14 August 2024

**SSD-50587460 – Panorama Battery Energy Storage System
749 and 800 Mid Western Highway, Evans Plains**

Council provides the following by way of comment on the application as lodged.

Plan Title:	PANORAMA BESS 100MW/200MWh	Drawing No:	CIV101
		Sheet No:	1
		Revision:	H

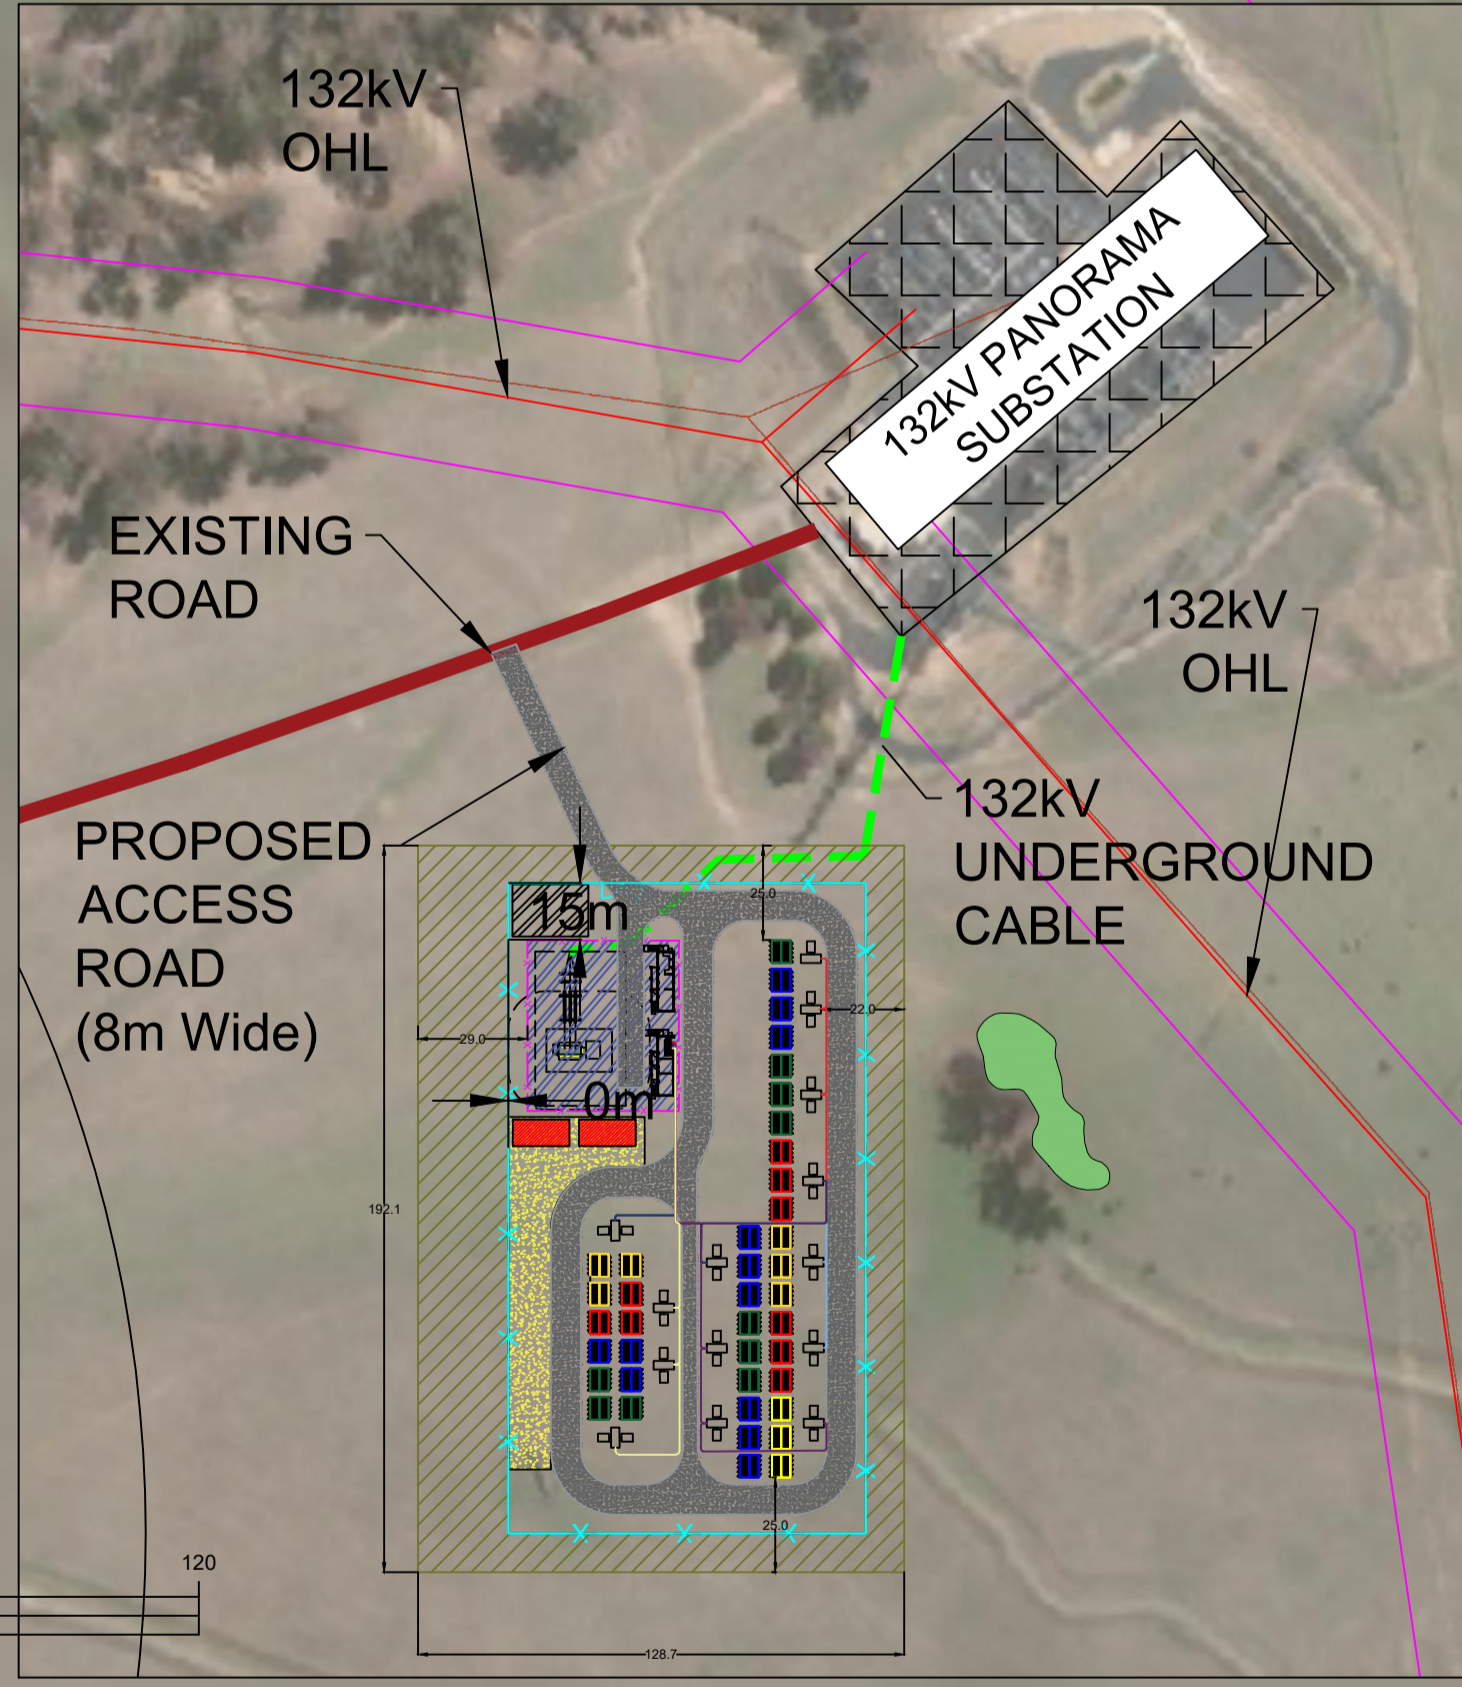
The Hazard and Risk Assessment suggests the installation of a secondary access road from the BESS connecting to the Mid Western Highway.

The impact of the construction of a secondary route is not considered elsewhere in the submitted documentation eg, potential for additional access to Mid Western Highway.
